DOC18/788647
SSD 9275

**Exhibition of Mixed-use student accommodation development at 80-88 Regent Street, Redfern
(SSD 9275)**

Attachment 1 – OEH comments on exhibition of Mixed-use student accommodation development at 80-88 Regent Street, Redfern (SSD 9275)

**Figure 17: Excerpt from design plans for Rooftop Terrace (Batesmart)**

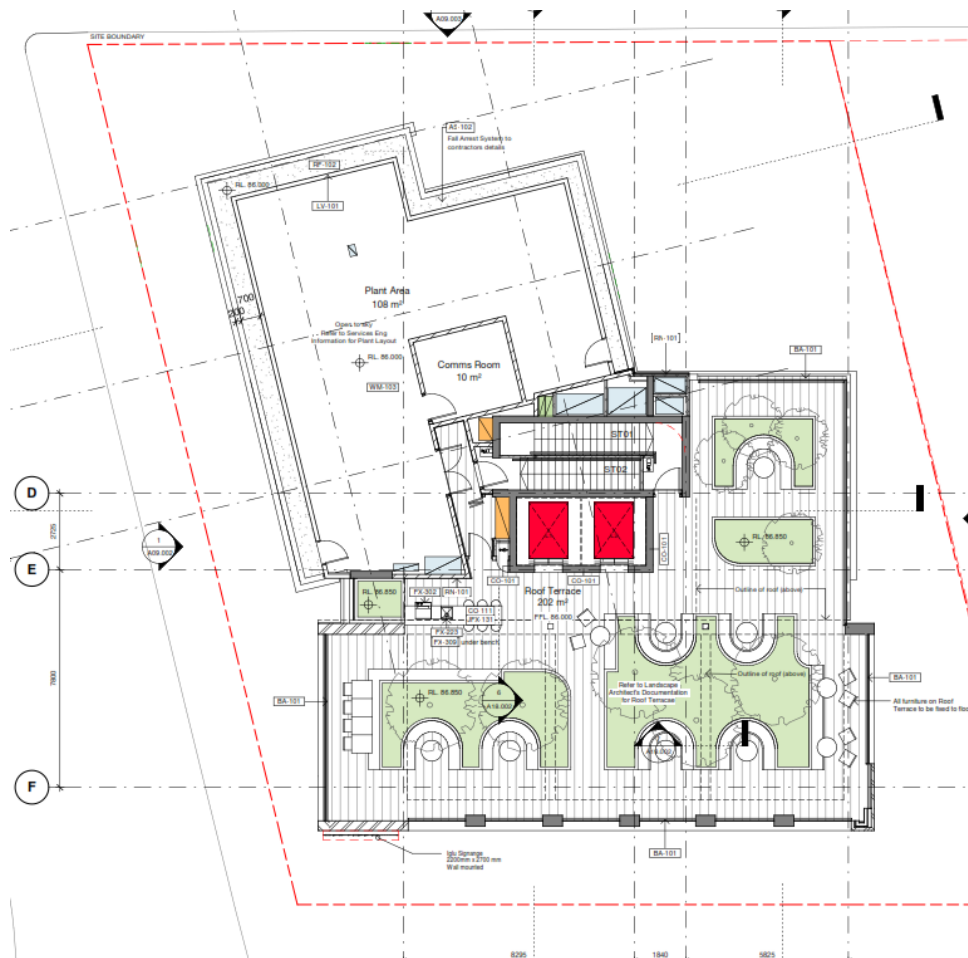
OEH recommends the development incorporate green walls (see example below), and where possible a more intensively planted green roof and/or a cool roof into the design. The benefits of Green Roofs and Cool Roofs are outlined in the *OEH (2015) Urban Green Cover in NSW Technical Guidelines* which can be found at the following link:

Green roofs can increase habitat and biodiversity at the site, particularly if local native plant species are used from the relevant native vegetation community. The selected plant species as shown on the landscape plan planting schedule and planting palette are mostly exotic and invasive weeds. OEH encourages their replacement with native species. A good opportunity exists to increase the long term sustainability outcomes of the proposal, given the rooftop terrace, level 01 internal courtyard proposed (as shown below) through intensive green roofs/walls etc. Additional green cover on site will assist with reducing the urban heat island effect, local temperatures and contribute to meeting Greater Sydney's urban tree canopy target of 40 per cent consistent with the District Plan's Planning Priority.
